From: Simon Davis
Sent: 07 June 2021 18:34
To: 'Jonathan Puplett | Whaleback' [REDACTED]
Cc: 'Gareth Giles | Whaleback' [REDACTED]
Subject: RE: BR/107/21/PL 283-285 Chichester Road Bognor Regis PO21 5AH

From: Simon Davis <Simon.Davis@arun.gov.uk>
Sent: 21 May 2021 13:38
To: Jonathan Puplett [REDACTED]
Cc: 'Gareth Giles | Whaleback' [REDACTED]
Subject: RE: BR/107/21/PL 283-285 Chichester Road Bognor Regis PO21 5AH

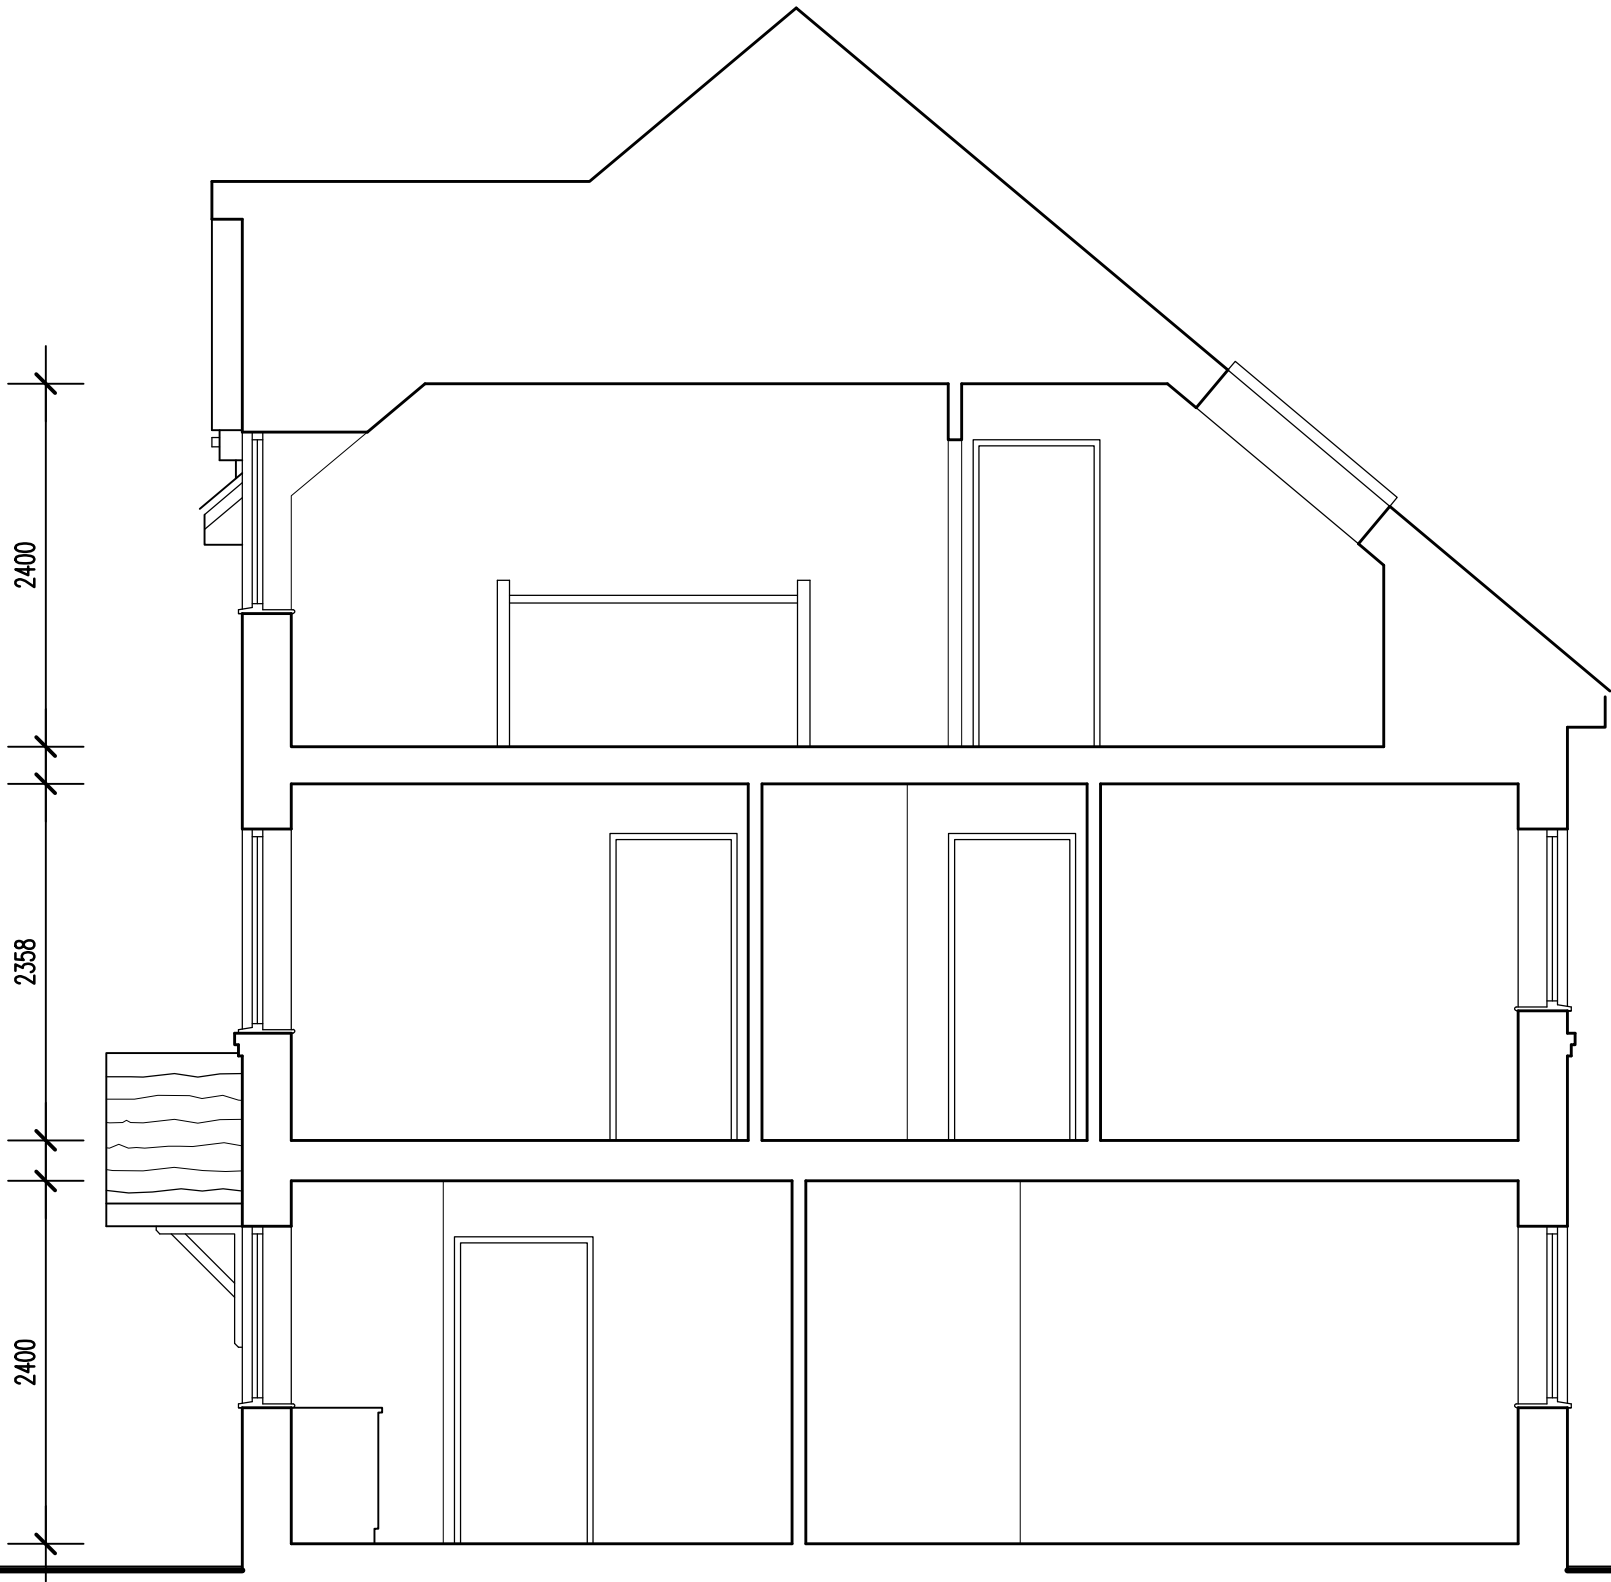
I am therefore reluctant to agree an Extension of Time and propose to determine the application as is. I also note that our local validation criteria does say that "Street scene drawings or photomontages are required when a proposal is set between existing development and is visible from the public realm. They should show how the proposal integrates with the adjacent buildings." Whilst the application was validated without this, it still should have been provided at the outset.

I had a chat with my Team Leader about this one yesterday. We have a current concern re the increase in height from two storeys to three and we will need to consider this further. I do acknowledge the three storey building opposite but this is also a prominent location which draws the eye when approaching from the north. In order to assist us in this, can you provide us with a streetscene drawing showing the proposed building alongside the existing adjacent buildings. Please also indicate whether there will be any change in ground and finished floor levels. Can you give me a timescale on when you can get this information to me.

Apologies for the delay in getting back to you. The architect has had to instruct some additional survey work to prepare the street scene drawing and the surveyor cannot get to site until the 17th of June. We will therefore have the drawings to you by the end of that week 21st June. We would be happy to agree an extension to the 31st of June to allow for this to be submitted and considered.
